**KIRKLEES METROPOLITAN COUNCIL
INVESTMENT & REGENERATION SERVICE**

DELEGATED DECISION TO DETERMINE PLANNING APPLICATIONS

Reference No:	2022/62/90404/E
Site Address:	8, Ashbourne View, Cleckheaton, BD19 5JE
Description:	Erection of three storey rear extension
Recommending Officer:	Elenya Jackson

DECISION – CONDITIONAL FULL PERMISSION

Drawing No. 166/03
Date
Jan' 22
Drawn by
RJB
Scale: 1:50
Page Size - A1

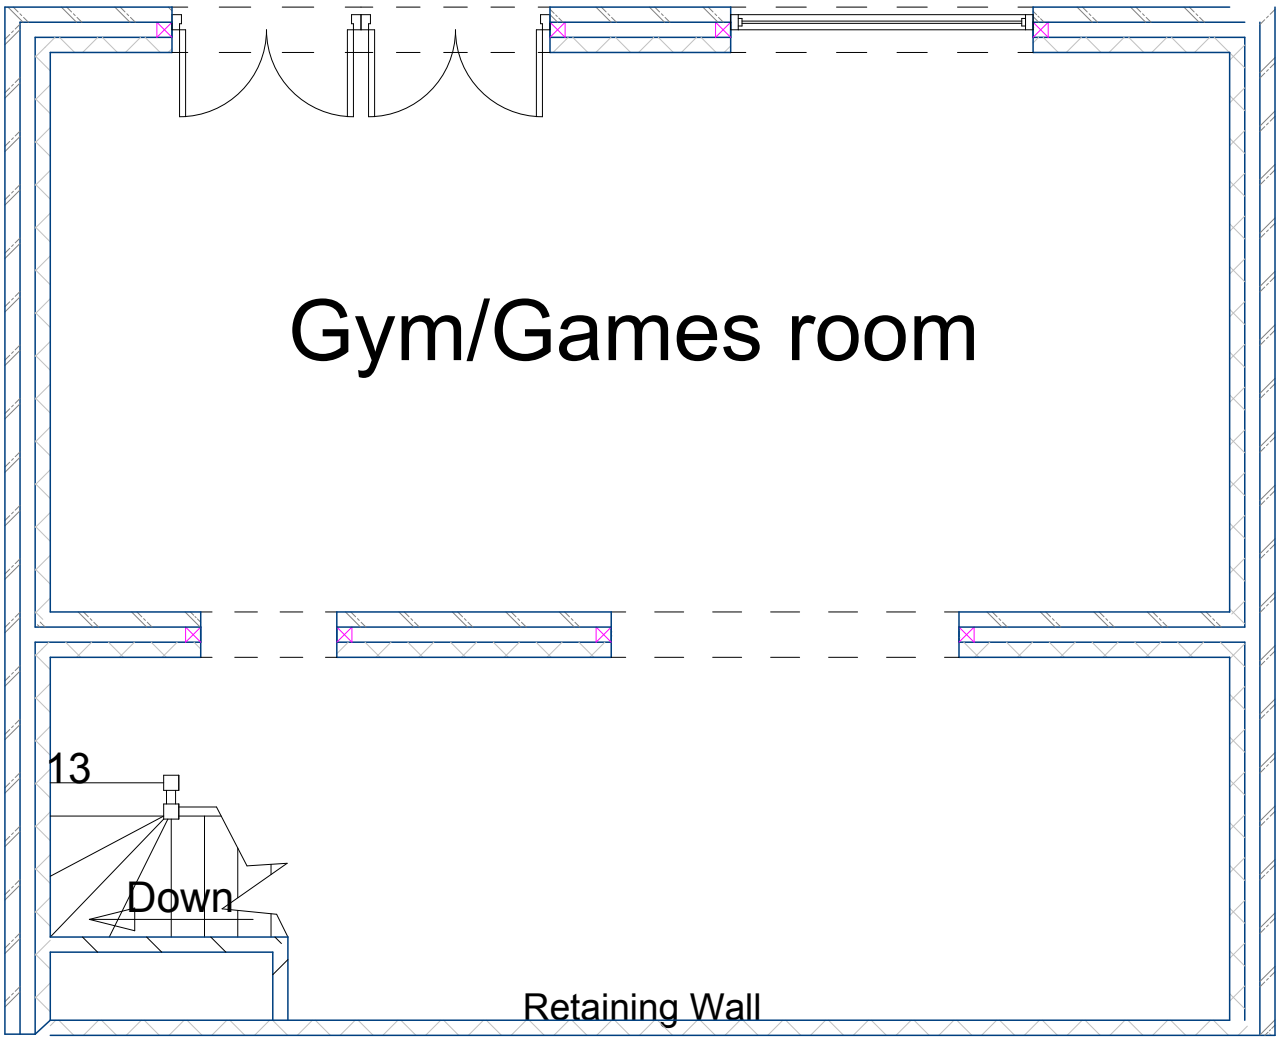
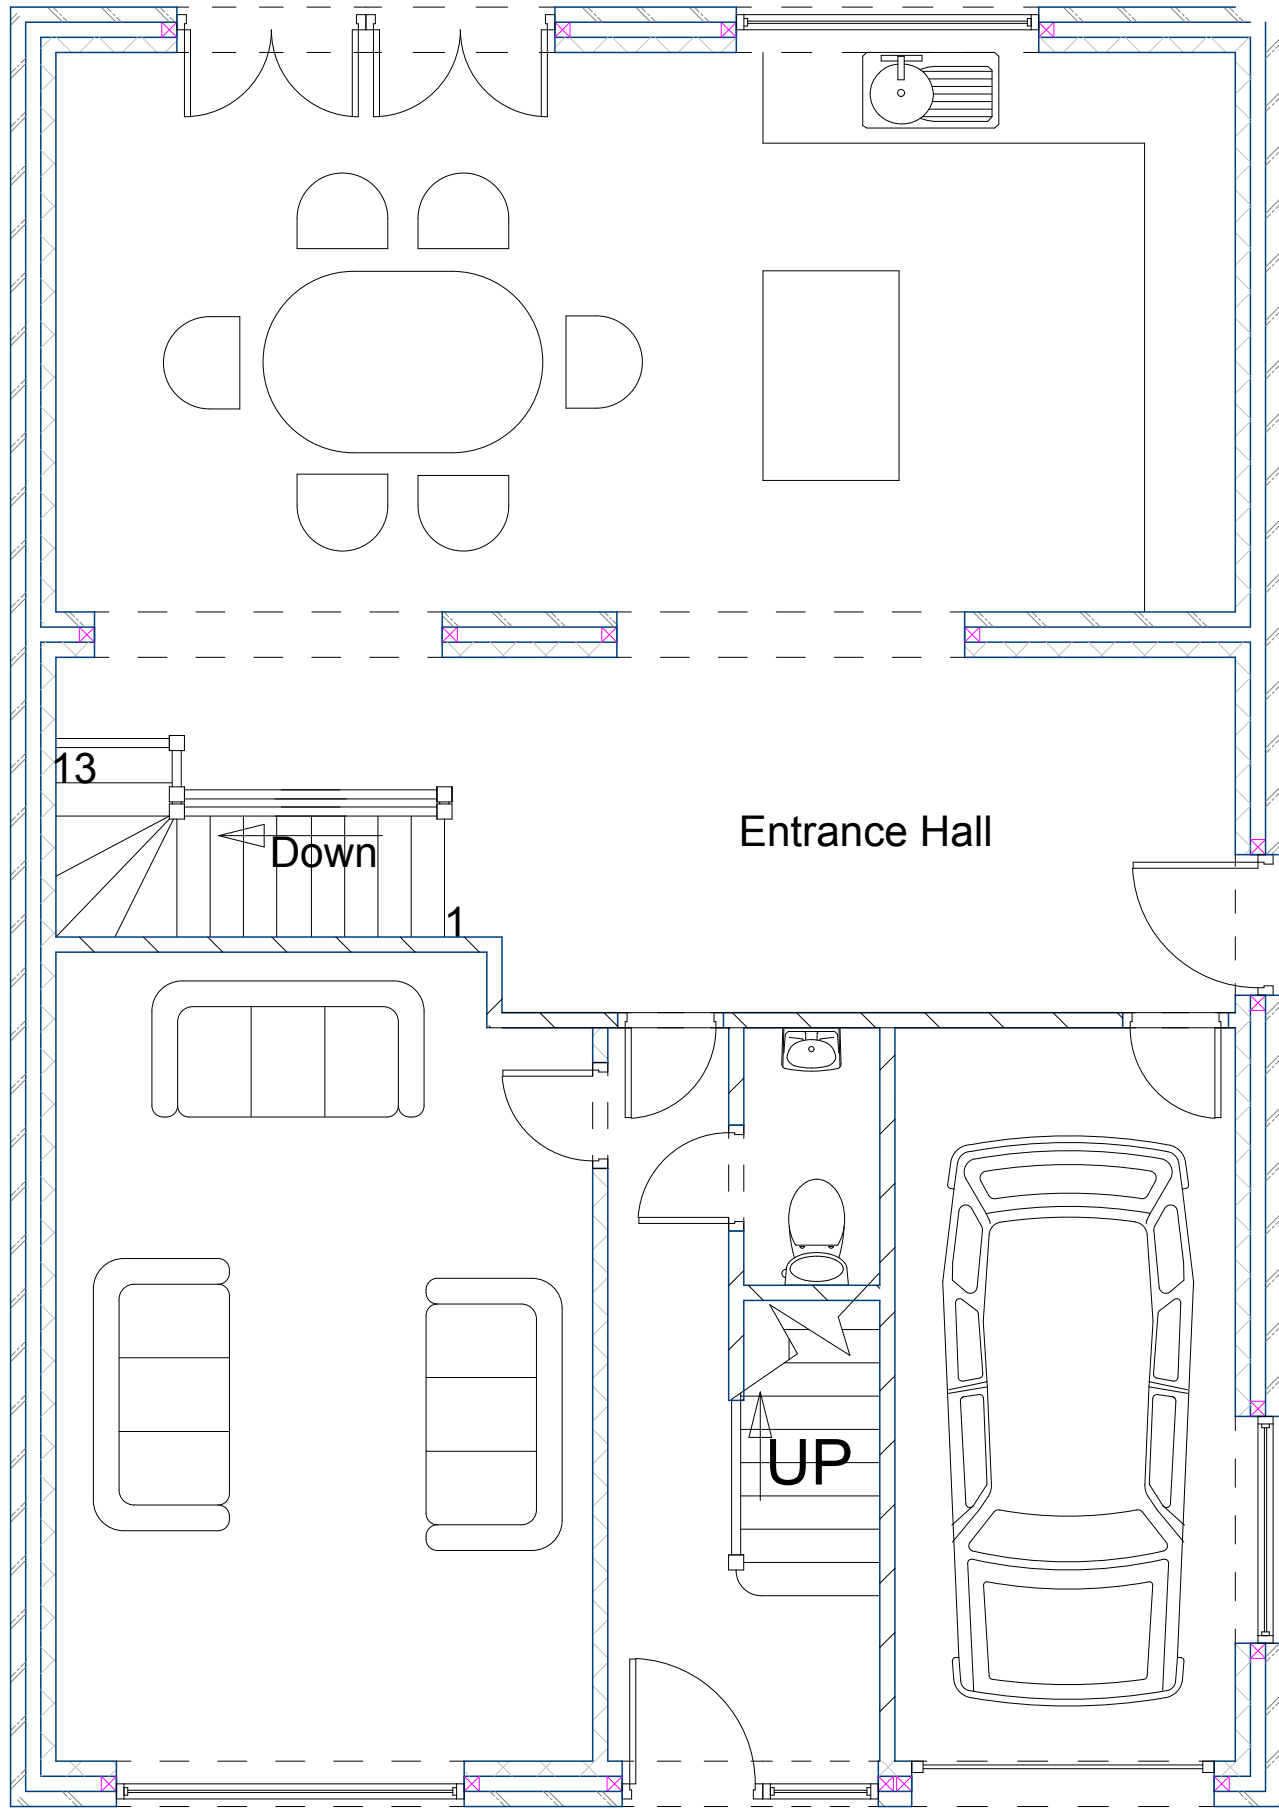
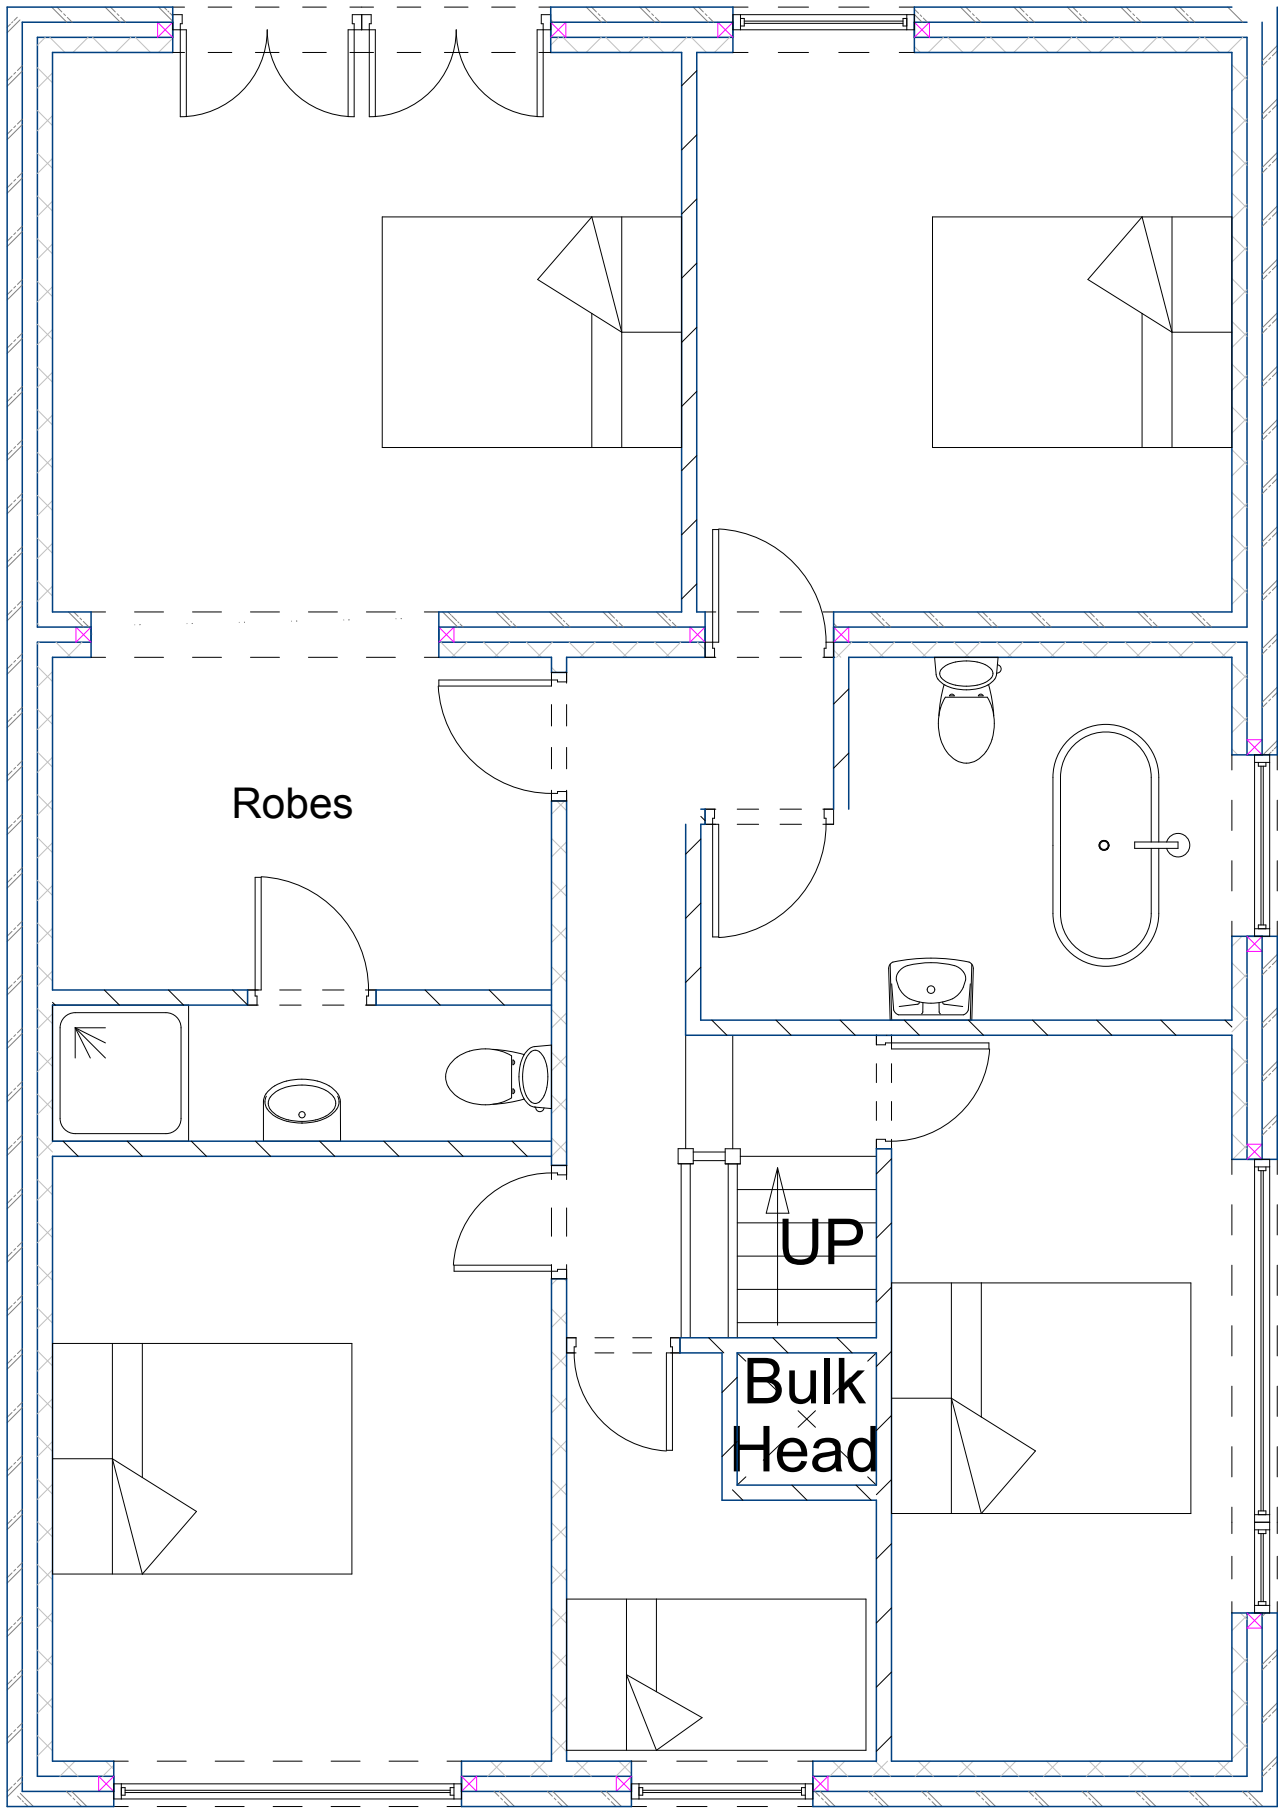
Overlooking: The proposal would feature one additional side facing window relating to a bathroom. As this could be conditioned to feature obscured glazing, no significant issues would be raised regarding overlooking.

4. Notwithstanding the provisions of the Town and Country Planning (General Permitted Development) Order 2015 as amended (or any Order revoking or re-enacting that Order) no doors, windows or any other openings shall be created in the either side elevations of the extension hereby approved.
